**SOIL/SITE EVALUATION
for ON-SITE WASTEWATER SYSTEM**

Proposed Facility:

REVISED 4/17/2009
RELOCATE PROPOSED HOUSE

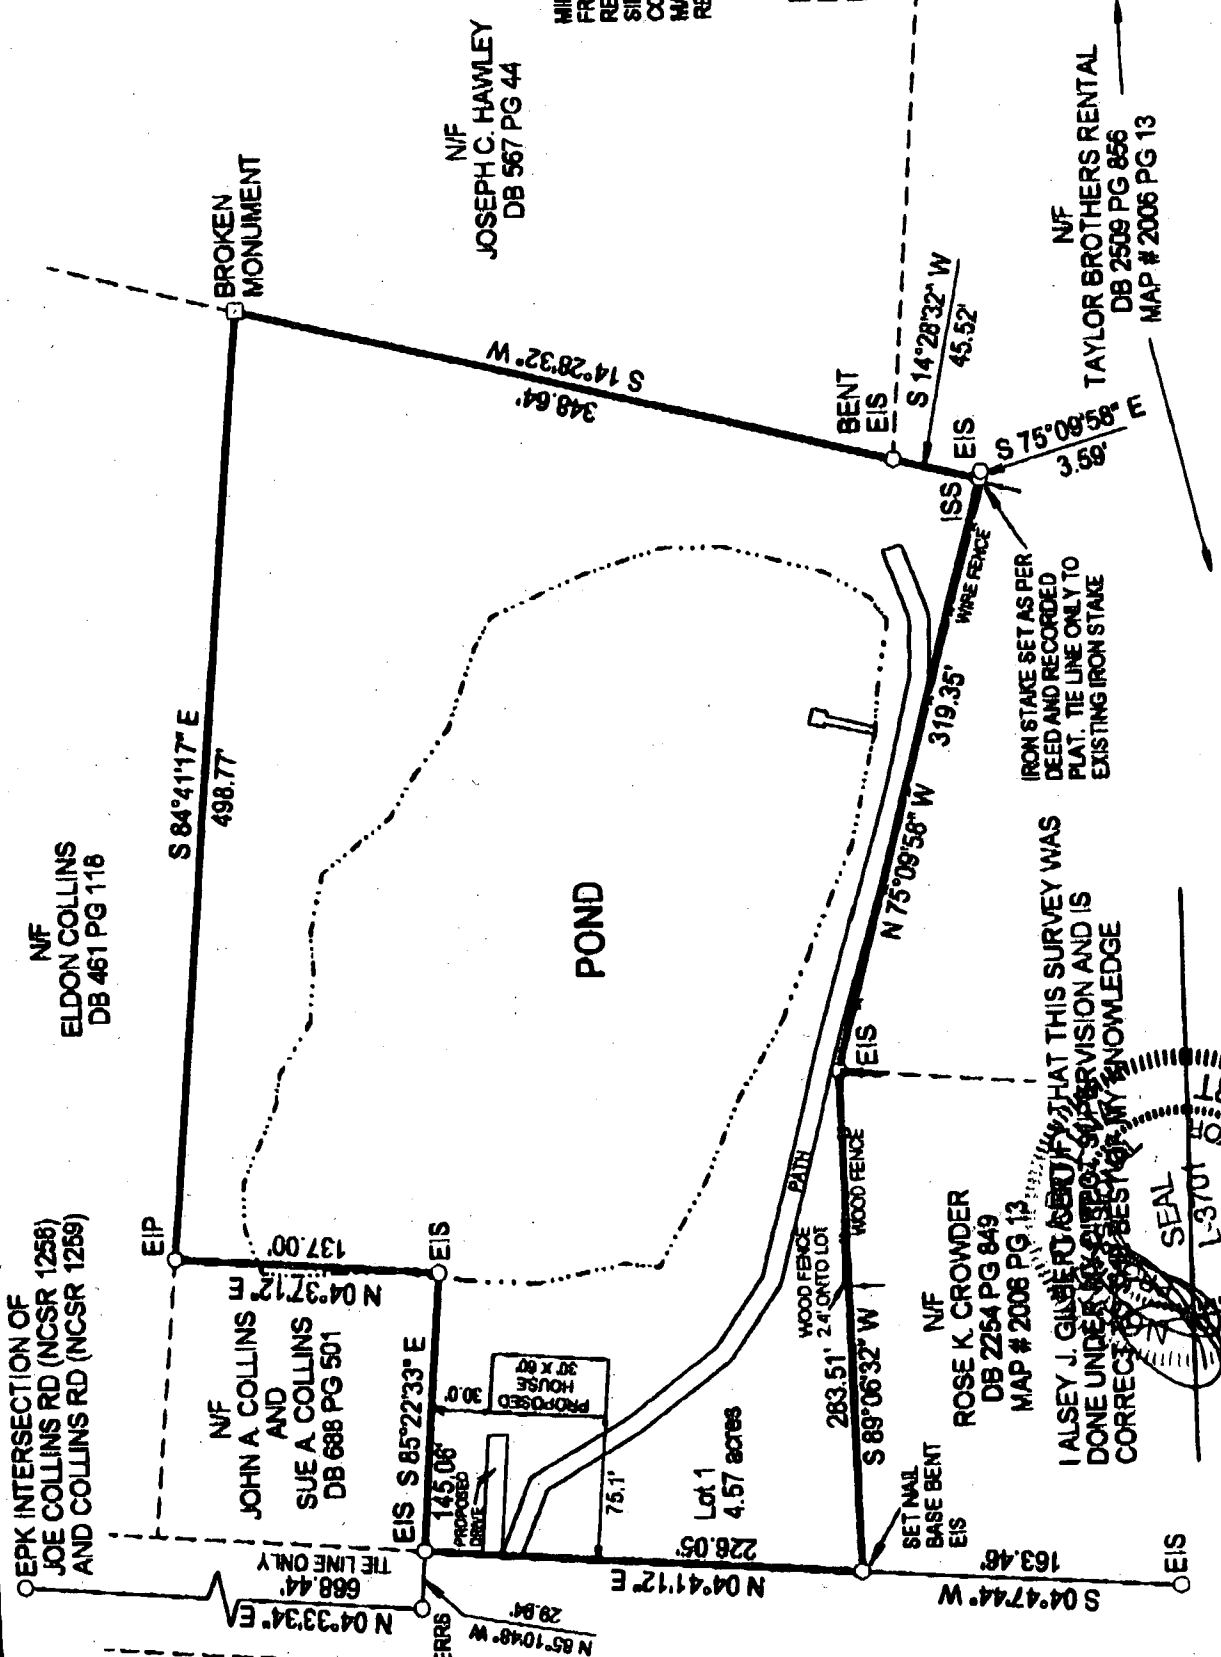
*700 of 25% soil.
700 m²
move house
to as shown
Wait on Dave - for
fill*
